From: ENVU Biodiversity and Land Use
Sent: 15 January 2026 10:17
To: Planning ContactCentre
Subject: doc 2025/93403 at location 1000, New Hey Road, Outlane, Huddersfield, HD3 3FJ

I understand that this is to review the discharge of conditions 7 and 8 of 2025/91413.

Condition 8 – lighting scheme

4 40W ASYMMETRIC LED FLOODLIGHT 20 DEGREE

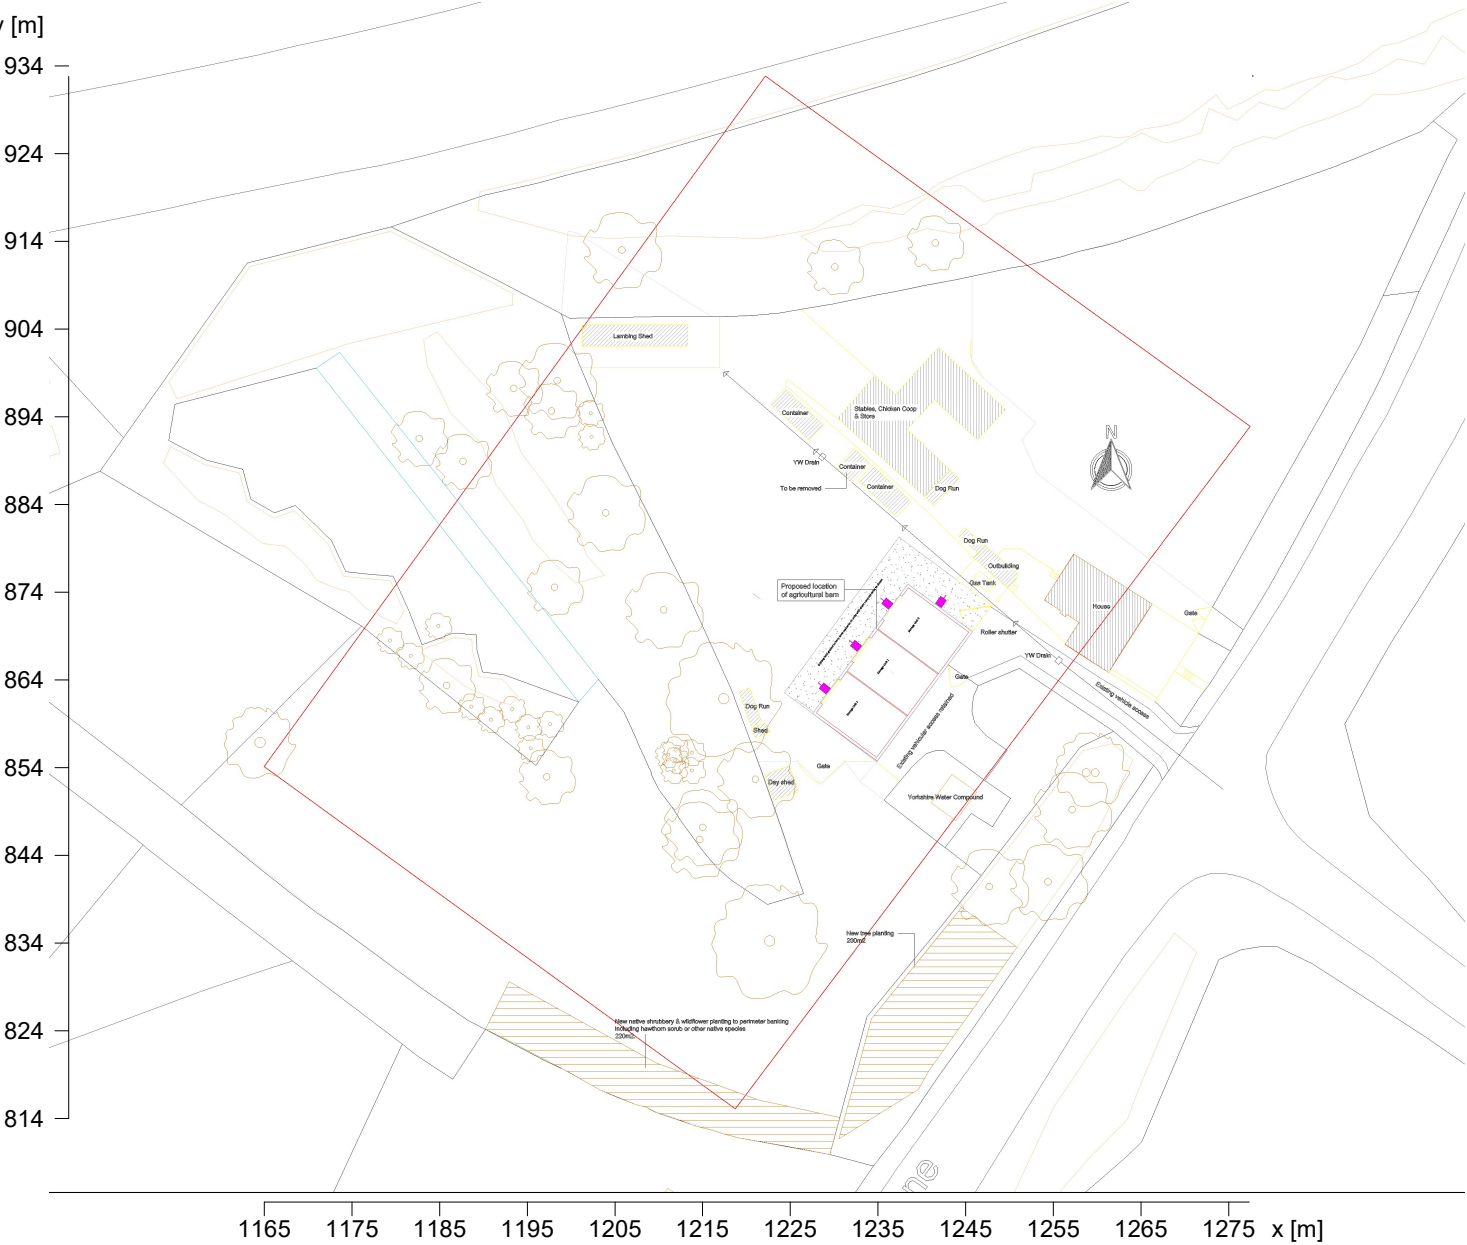
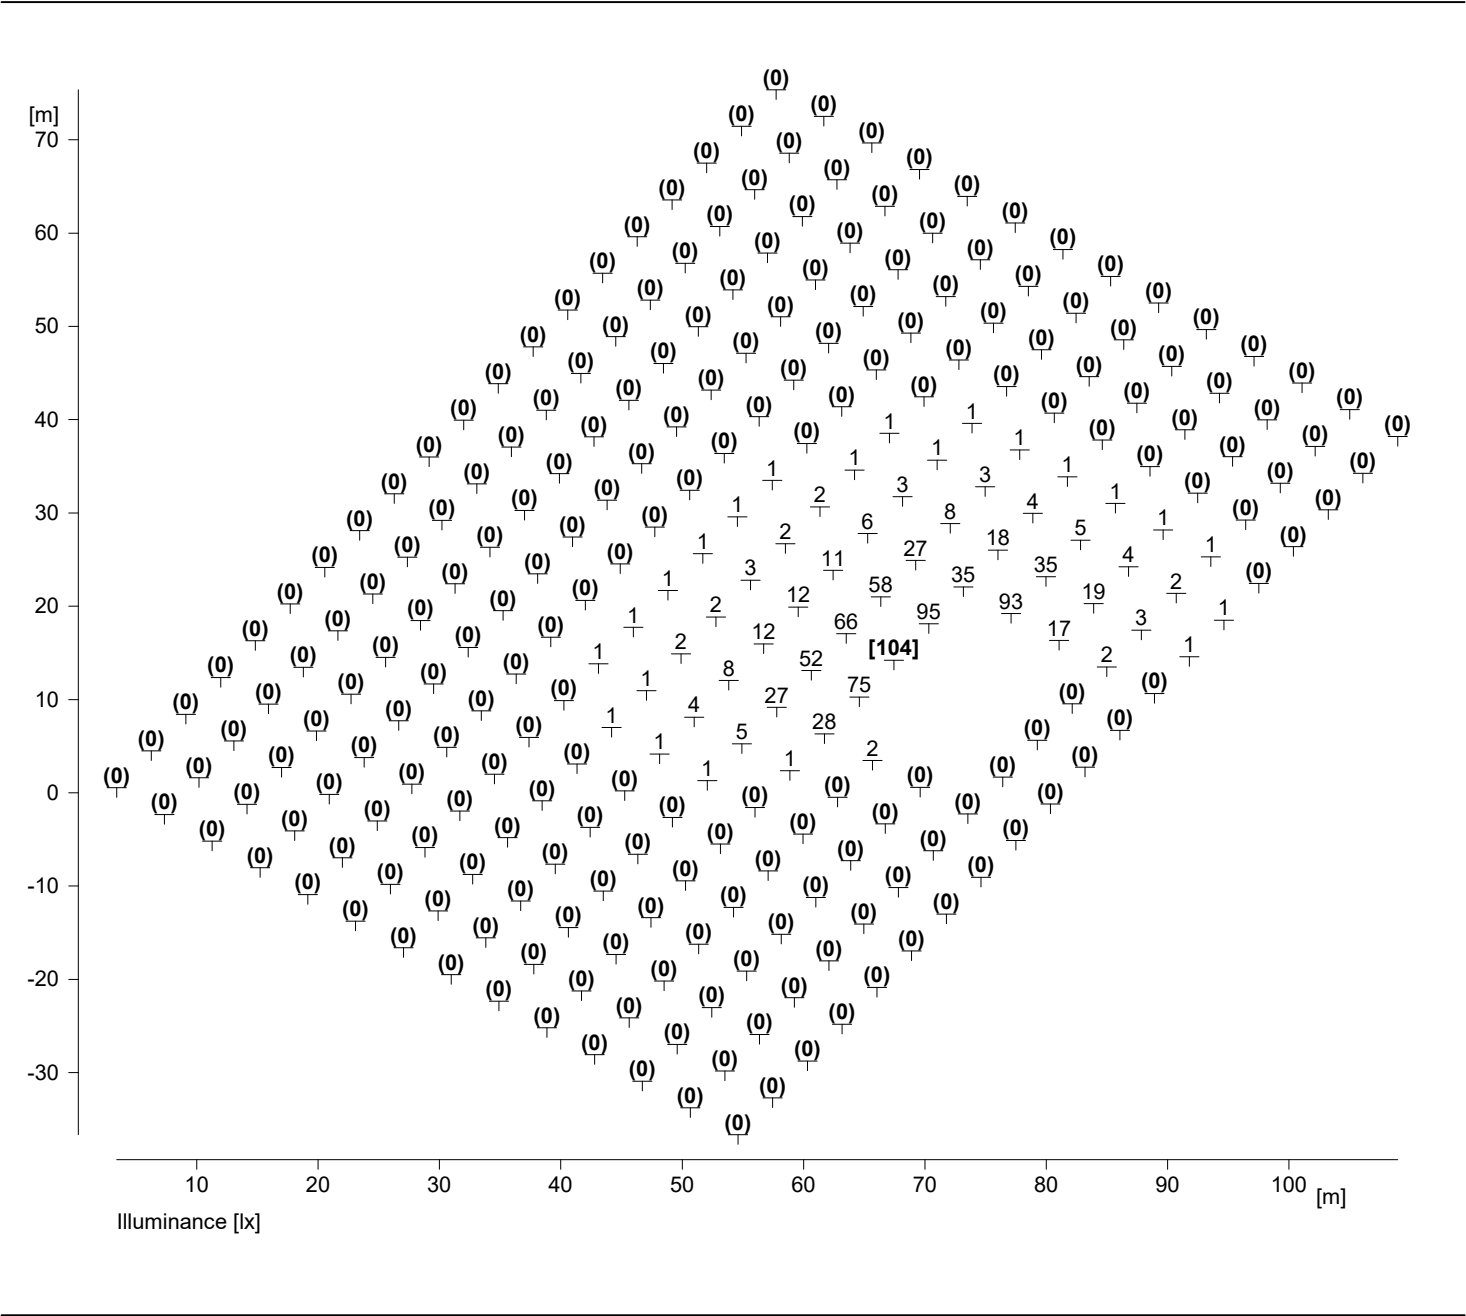
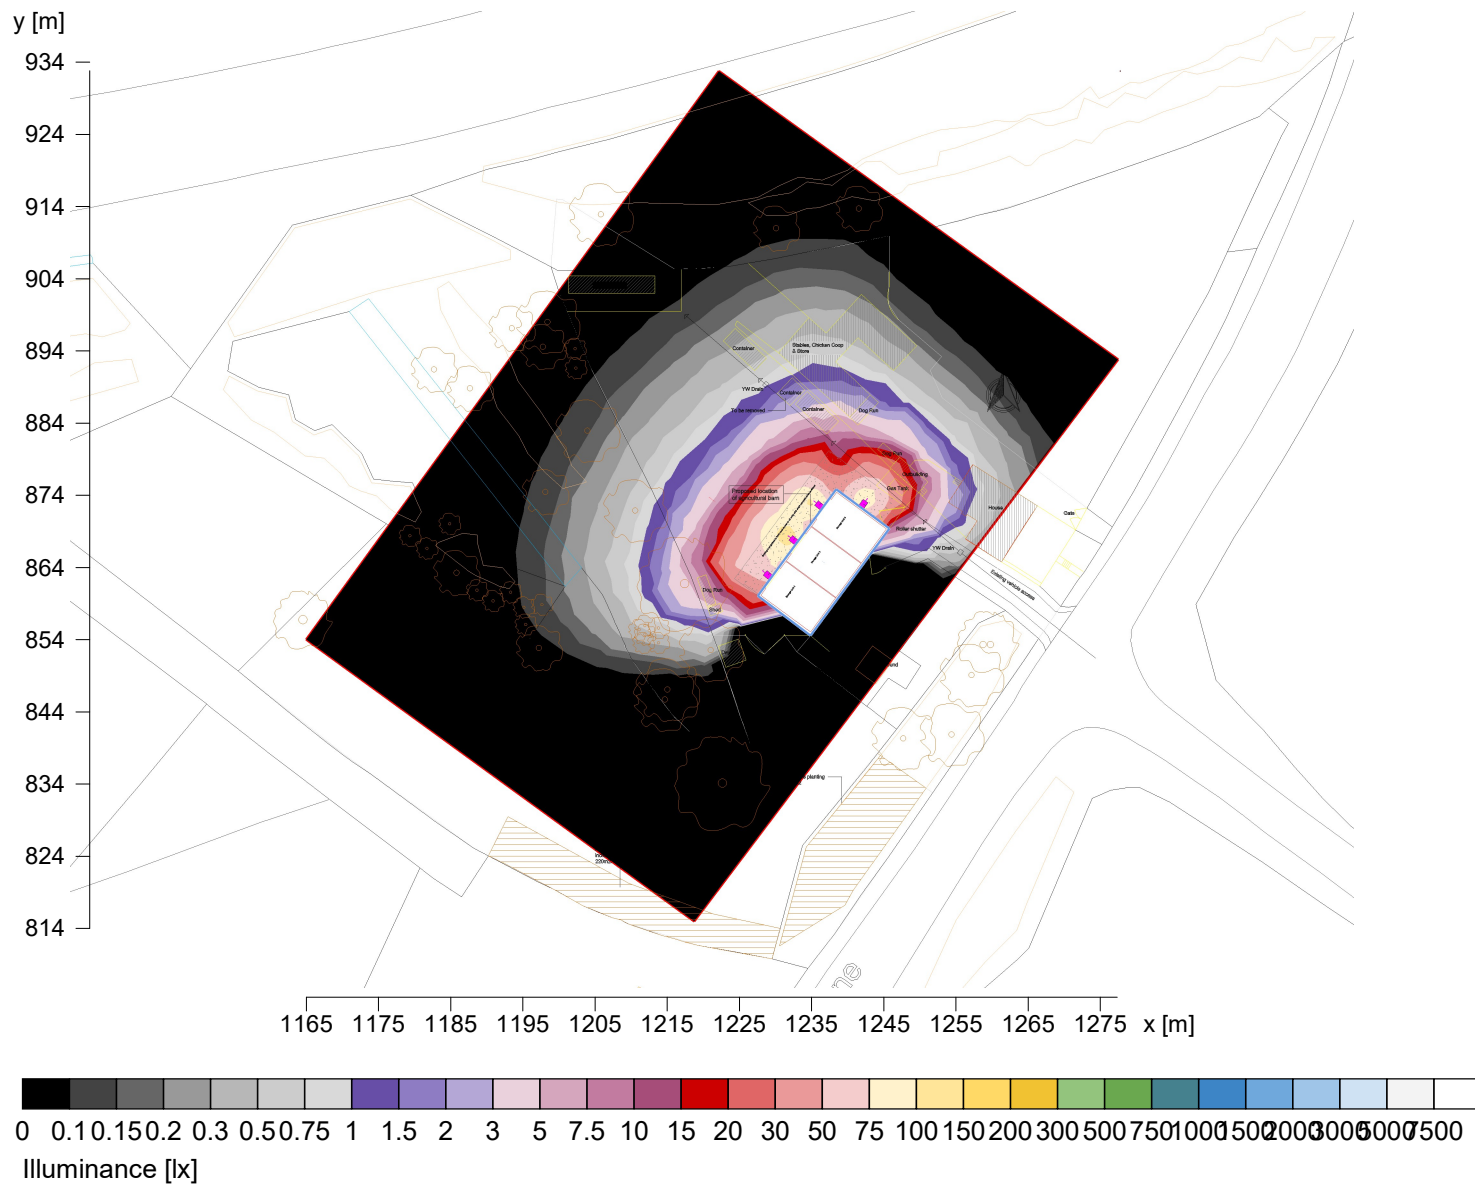
The lighting design document has been reviewed, however, there is not mention as to whether the design is in line with established wildlife lighting design e.g. Bat Conservation Trust and Institute of Lighting Professionals (2023) Bats and Artificial Lighting at Night – as required by the condition.

Condition 8 is not yet met.
